MEMORANDUM

FROM: Jeff Rice, PCD-Engineering **CCES Responses in red**
719-520-7877

SUBJECT: CDR-22-006 – Sterling Ranch Road Bridge
Second Submittal

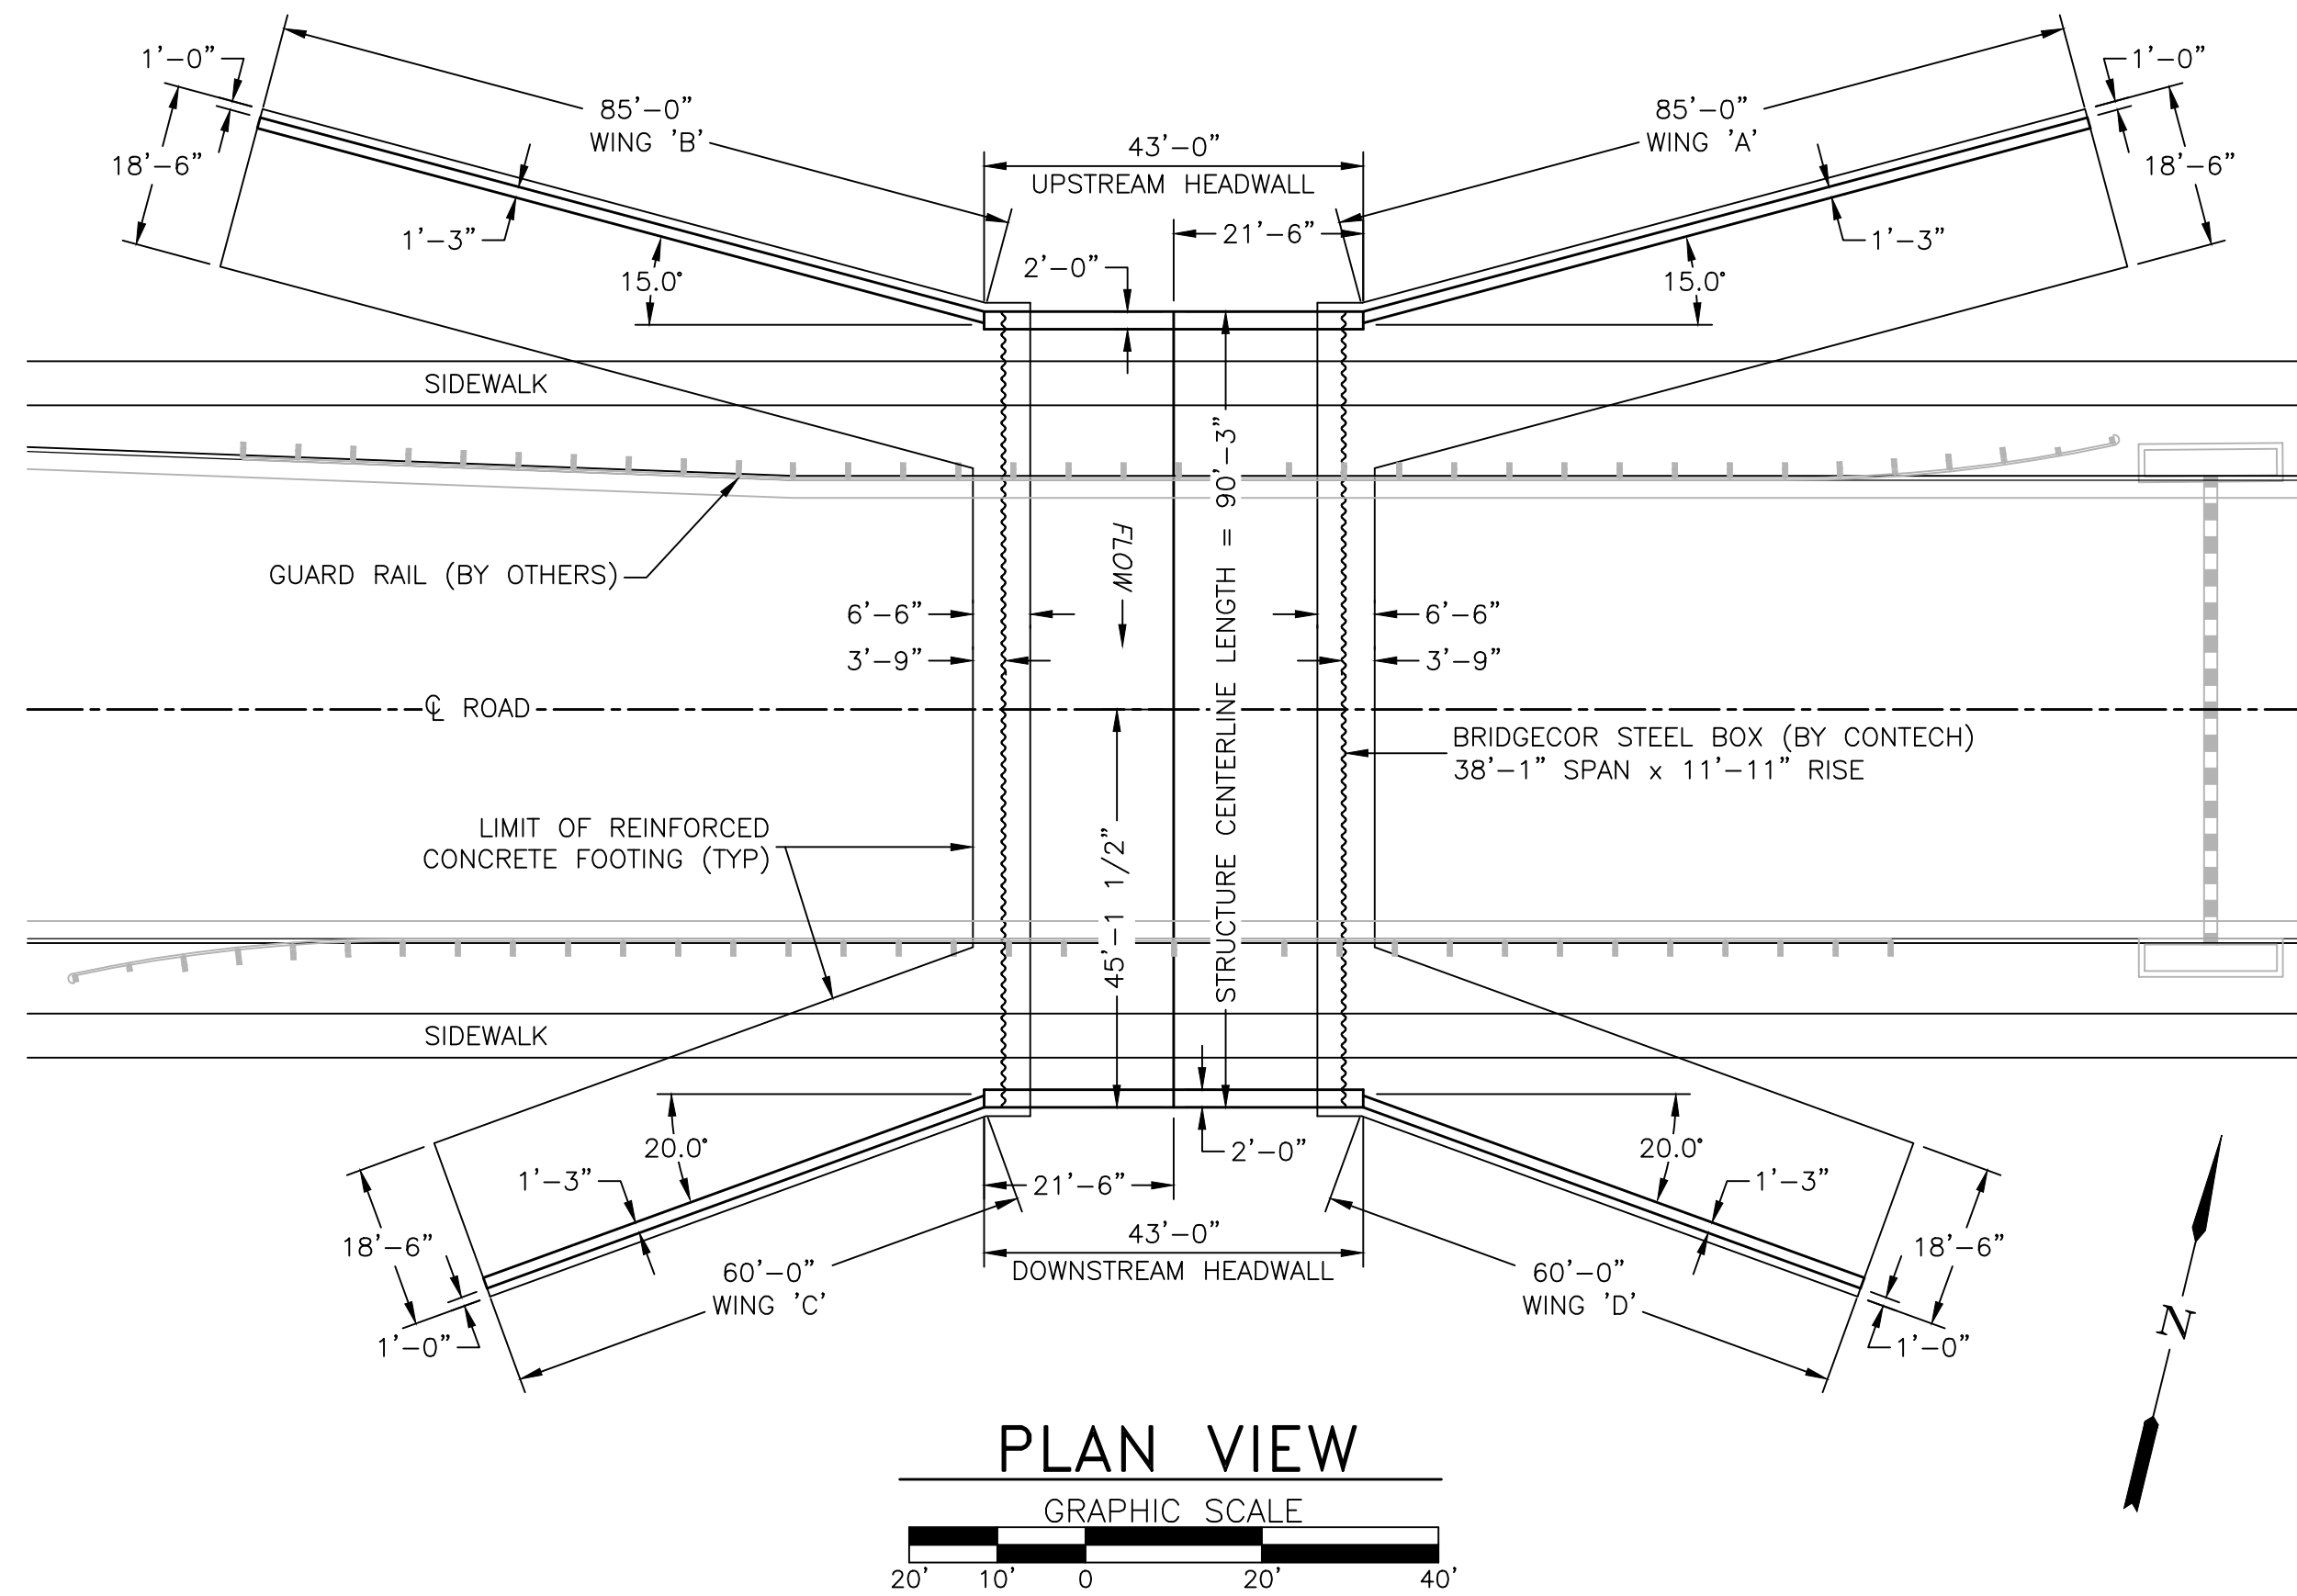
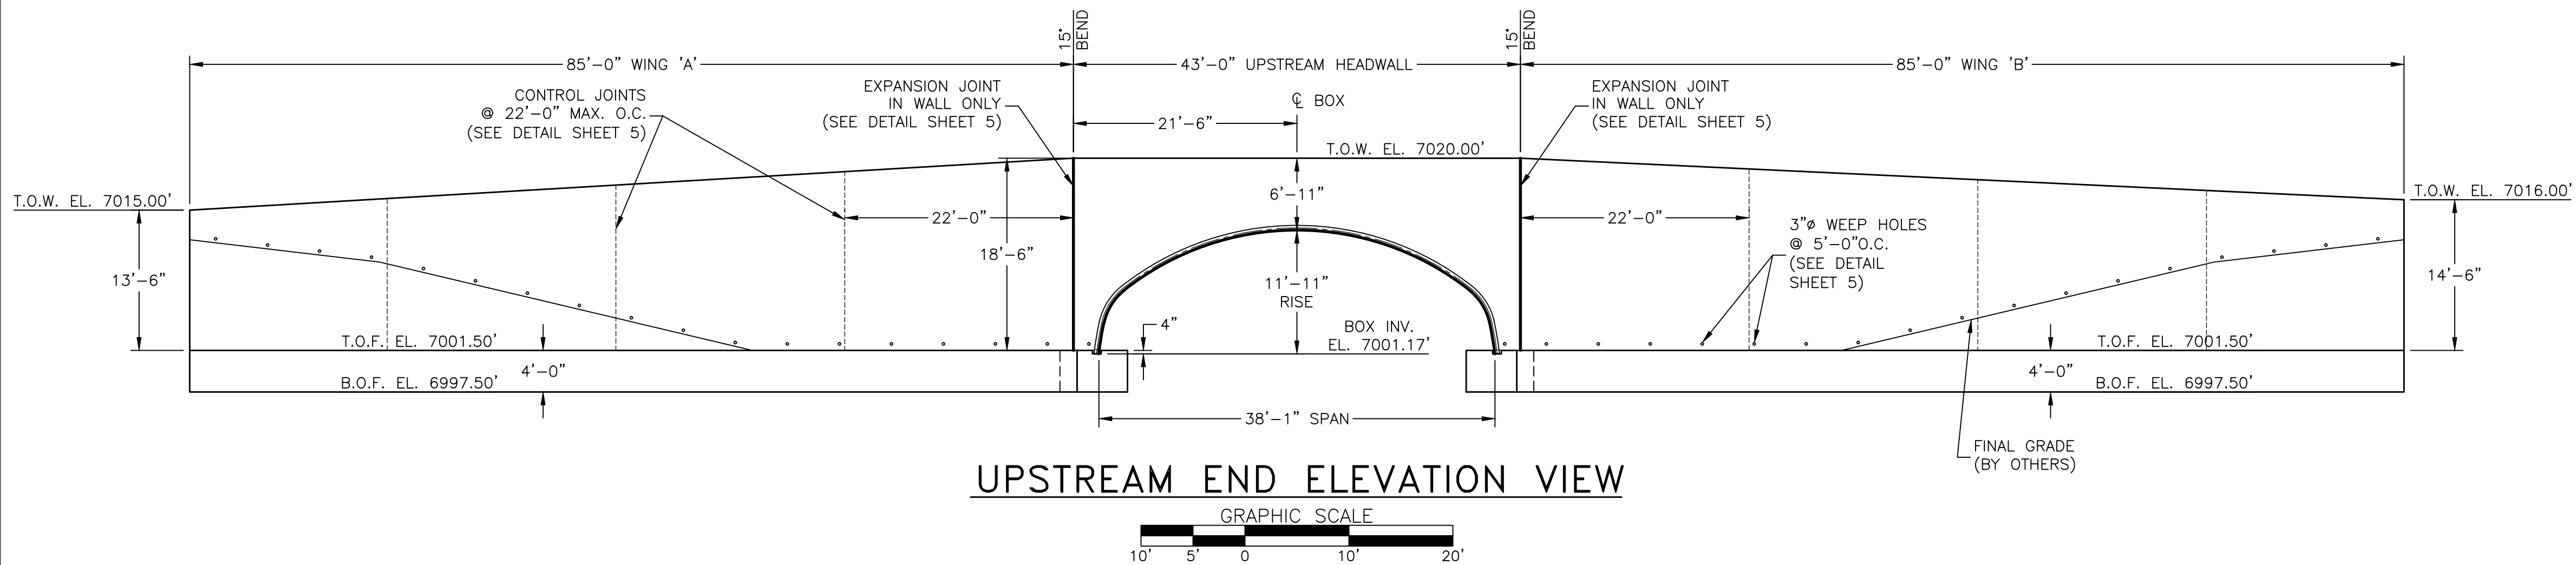
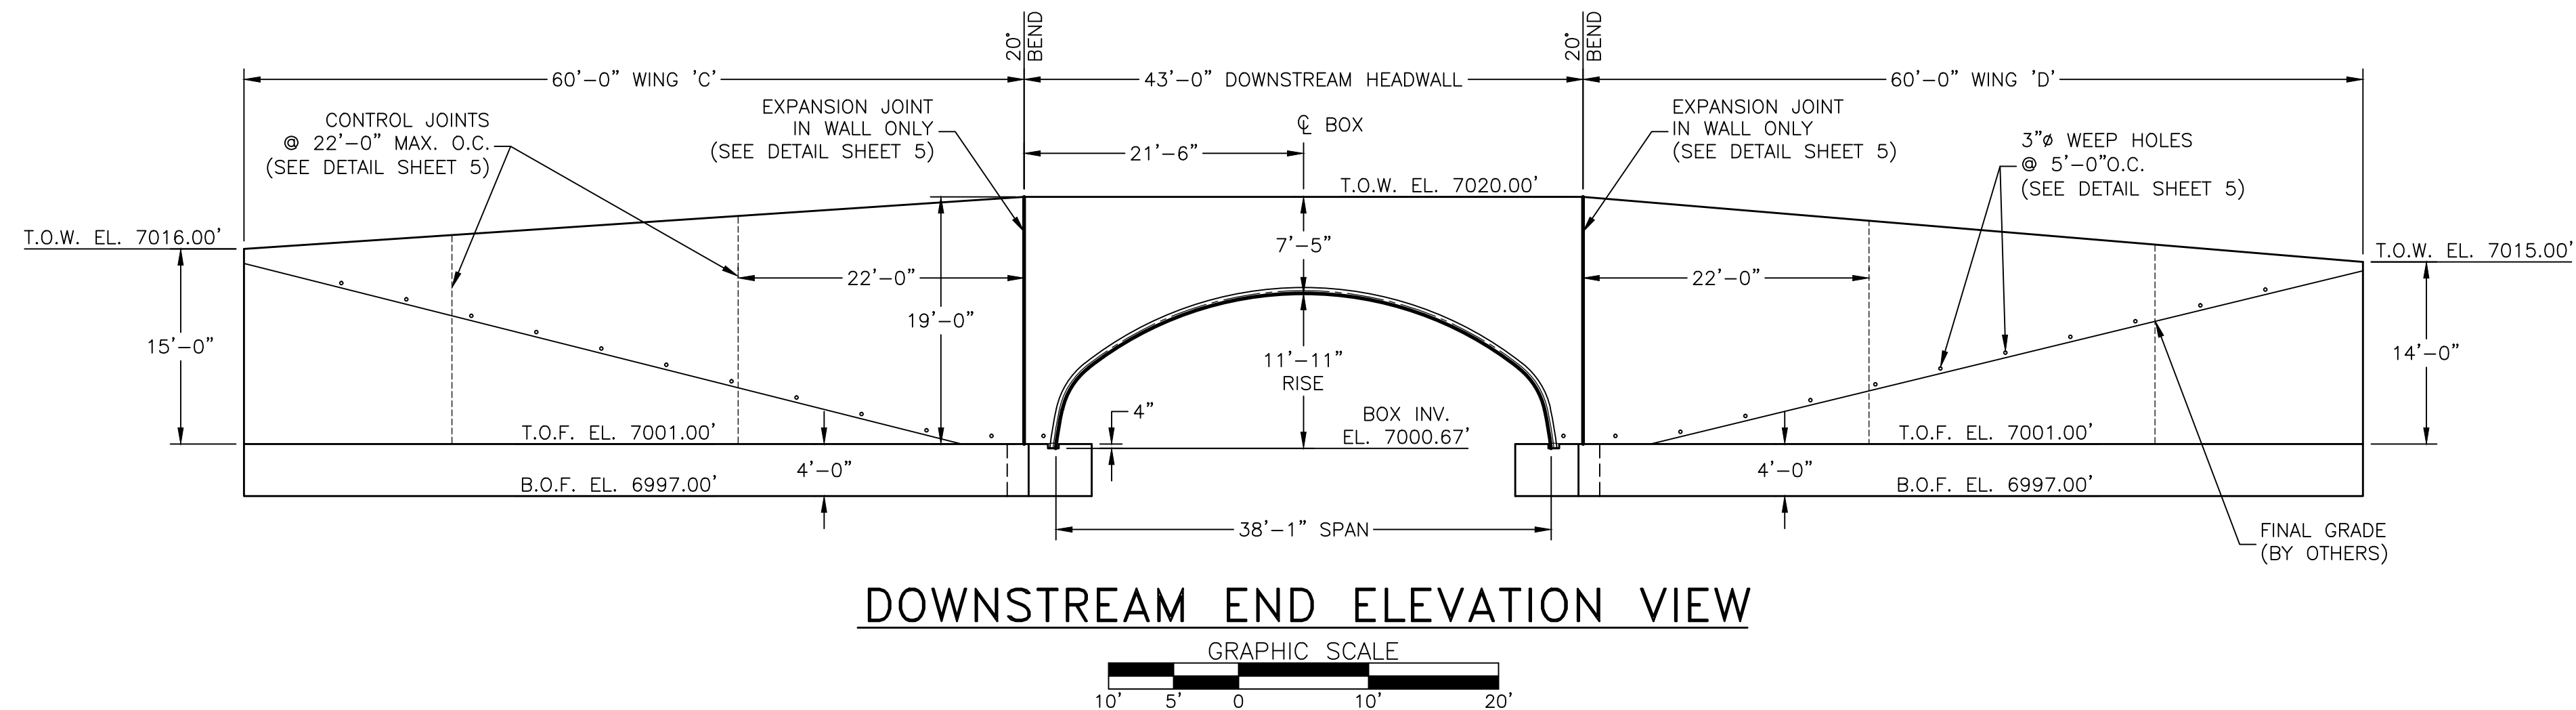
1. See GEC redlines. **Partially resolved; see updated GEC redlines. Revised**
2. **Resolved.**
3. Clarify whether the footings are to be constructed only on sandstone subgrade. Please provide a formal response to these comments. **Unresolved. Please include the memo from Entech in the EDARP submittal. Entech Addendum provided with this submittal**
 - a. Section 5.1.1 of the Subsurface Soil Investigation states that extensive subgrade improvements are anticipated and a maximum ultimate bearing pressure of 5,000 psf is recommended, but for undisturbed sandstone, the allowable bearing capacity is 5,800 psi. The footing design report states that Ultimate Bearing Resistance is 14,500, resulting in a factored bearing resistance of 8,700 psf. Please clarify.
 - b. Address how the footings will tie in to undisturbed sandstone if it is higher or lower than the bottom of the footings.

The foundations were designed based on Entech's Bearing Capacity Table with the bottom values. 5 foot embedment in rock with 8500 psf allowable bearing capacity. Per the test borings (TB1) sandstone is only 4' below grade.

Bottom of footings are at 6996.
